DAVID M. WHITE, ARCHITECT

6 March 2013 (revised)

Re: The Bay House

SITE PLAN
 OF:
THE BAY HOUSE
 112-113 NEWBURY STREET, 740 HANCOCK STREET
 PORTLAND, MAINE
 FOR:
THE VILLAGE AT OCEAN GATE, LLC
 35 FAV STREET, SUITE 407B
 BOSTON, MA 02118-4320

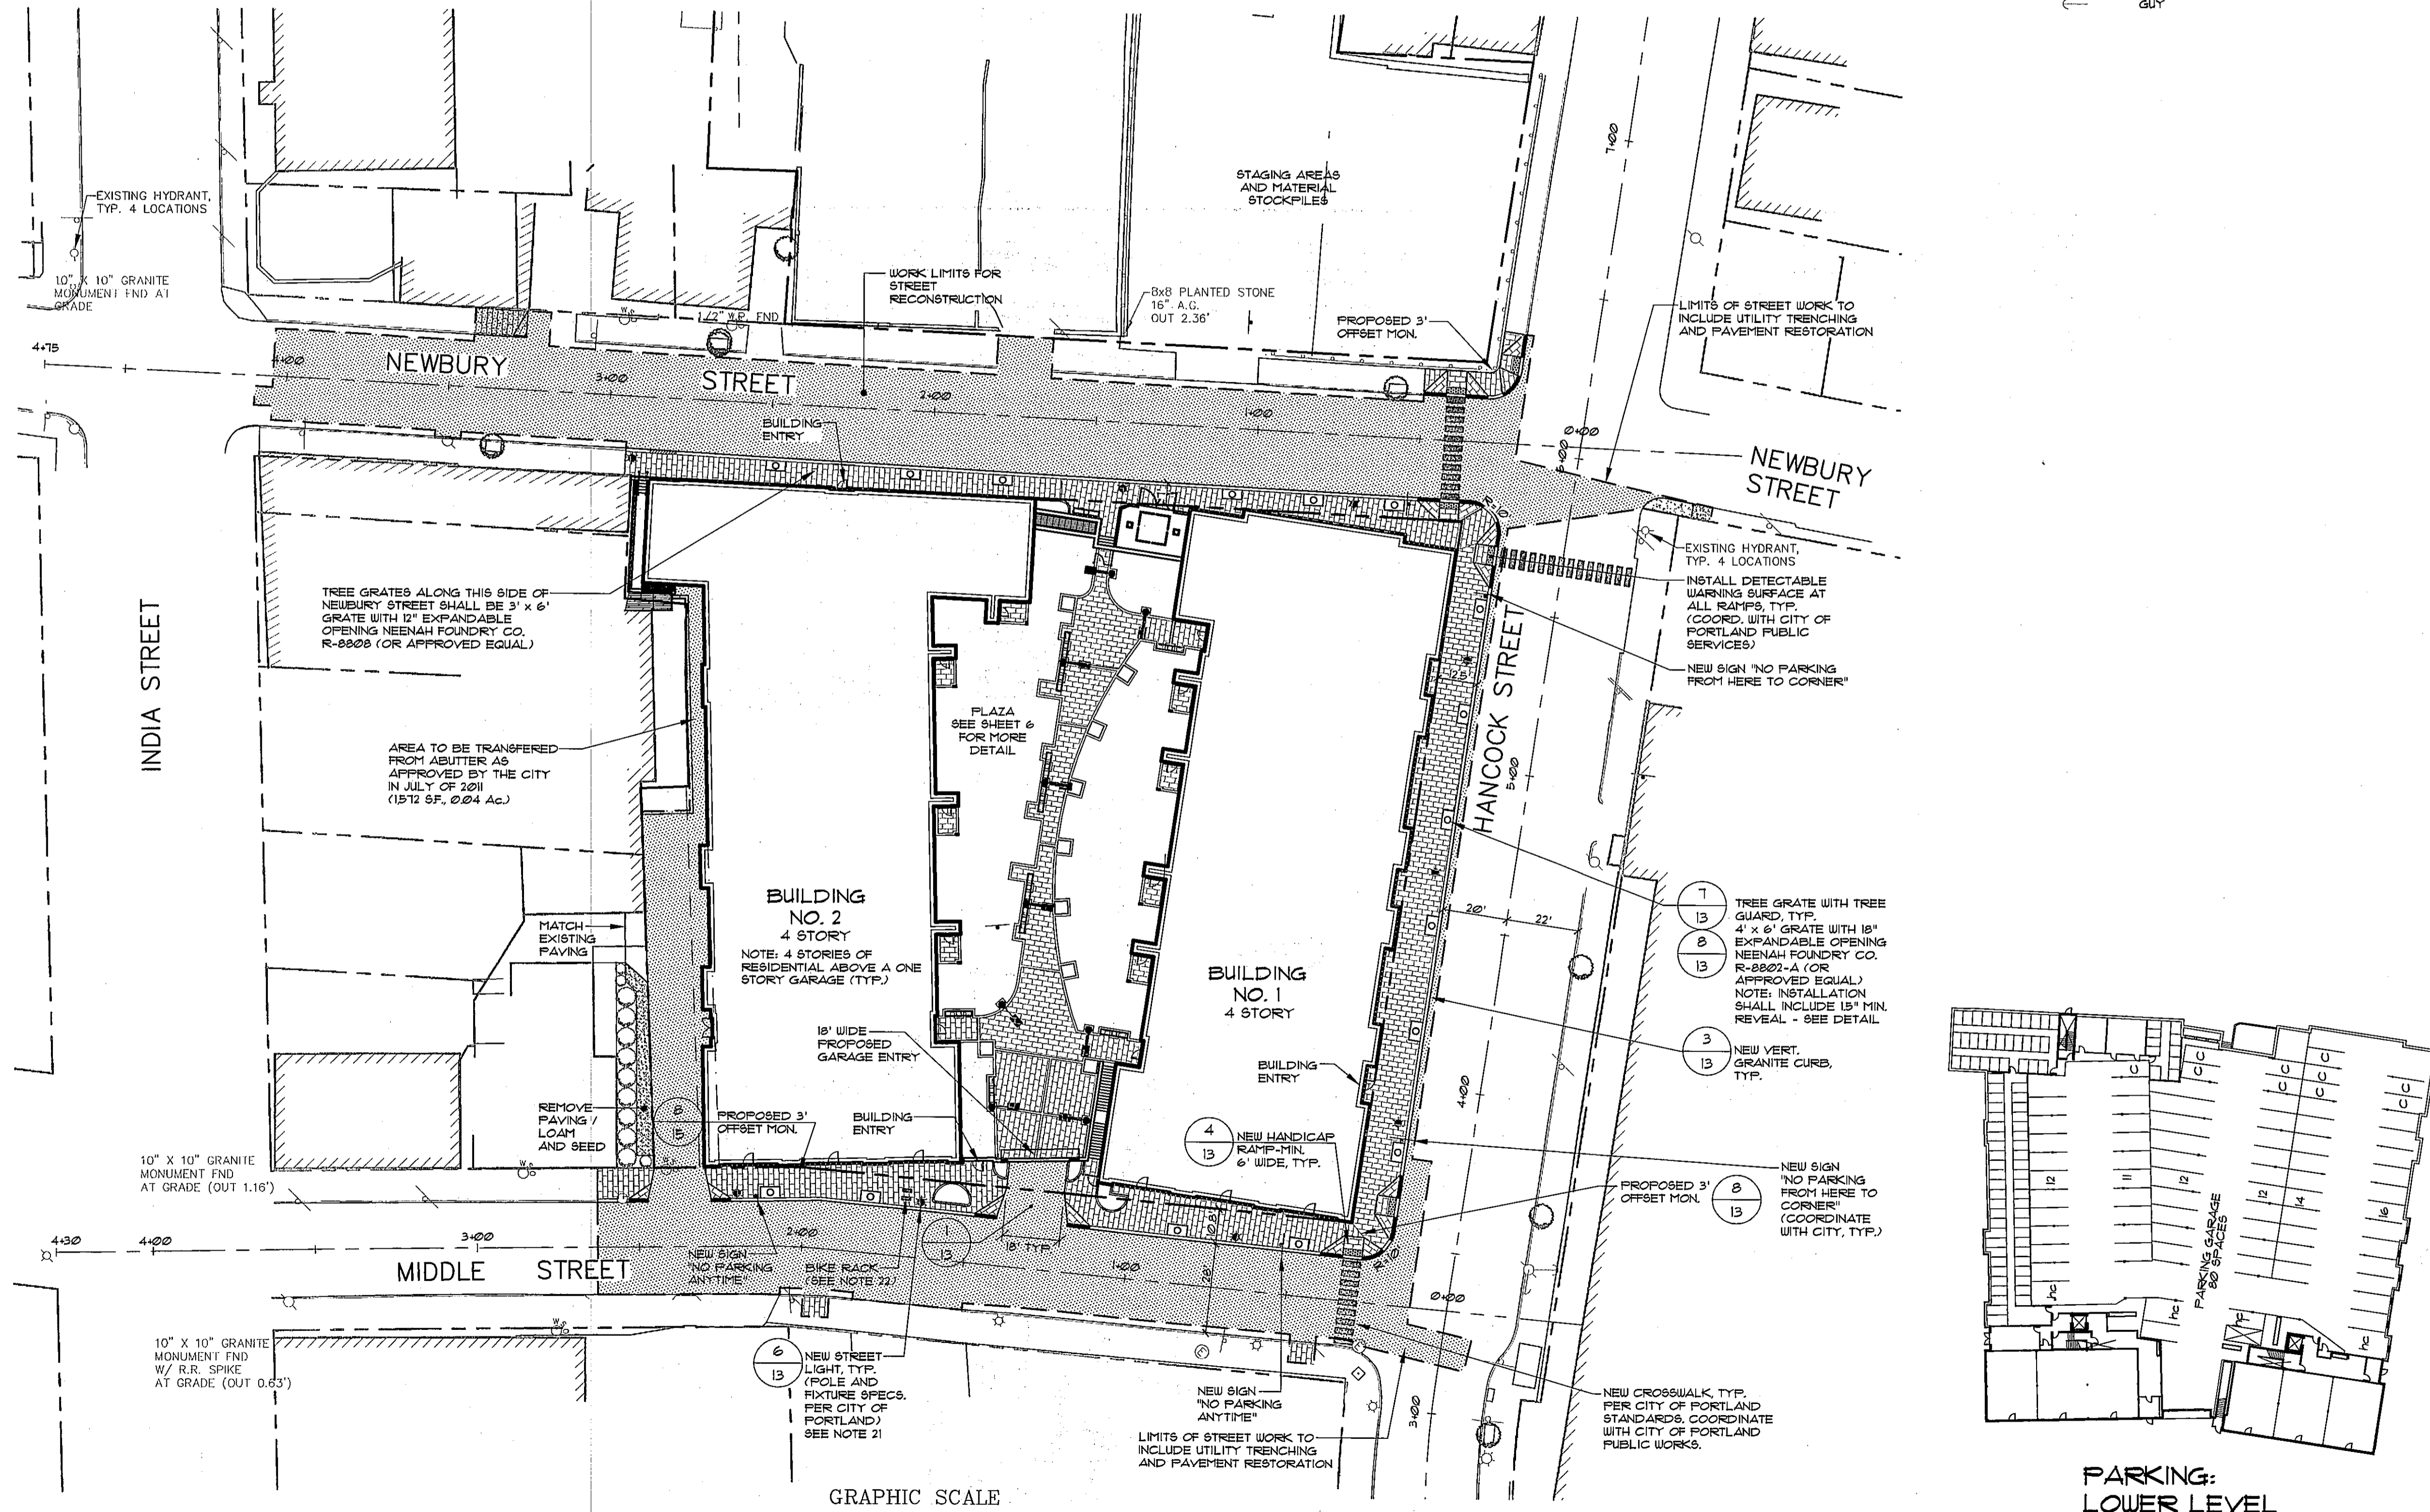
In order to accomplish this we added a ramp from Newbury Street to the courtyard. The original stair remained in its approximate original location. Also included as a result of the ramp was the relocation of the areaway for the fans servicing the carbon monoxide system in the garage. This areaway was located where the new ramp is located and was relocated on the left end of Building 1 as it faces Newbury Street.

Prior to making this change the Owners elected to provide a surface mounted transformer instead of in a vault under the sidewalk and right of way. This is also shown on the revised elevations.

the existing population of the area. This has lead to a decorative fence at those areas which would be in reach of a person who might want to breach the existing proposed walls and gates. This occurs at both ends of the courtyard, although the fence and gate at the Middle Street end is minimal. We have asked the contractor to provide us with the design and materials for this fencing so we can deliver it to your office for review.
